Demolition of single storey lean-to & erection of single storey rear extension. This application affects the character & appearance of the Littlehampton Seafront Conservation Area & may affect the setting of a Listed Building
13 Norfolk Road Littlehampton

Thank you for your internet representation made on 28th November 2018 which has been recorded as '**an objection**' with the comments as follows:

SOUTH ELEVATION Drg no 2018/MEL/04A Aug 2018 Scale 1:50@A3

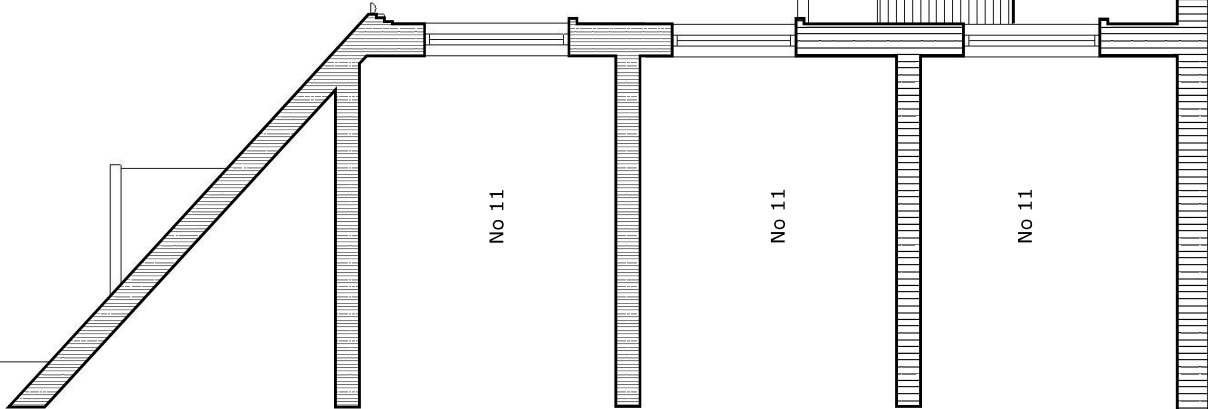
We do not understand why the proposed extension would be mounted on the Party Wall, as the wall is a single 11.5cm wall and is in very poor condition.
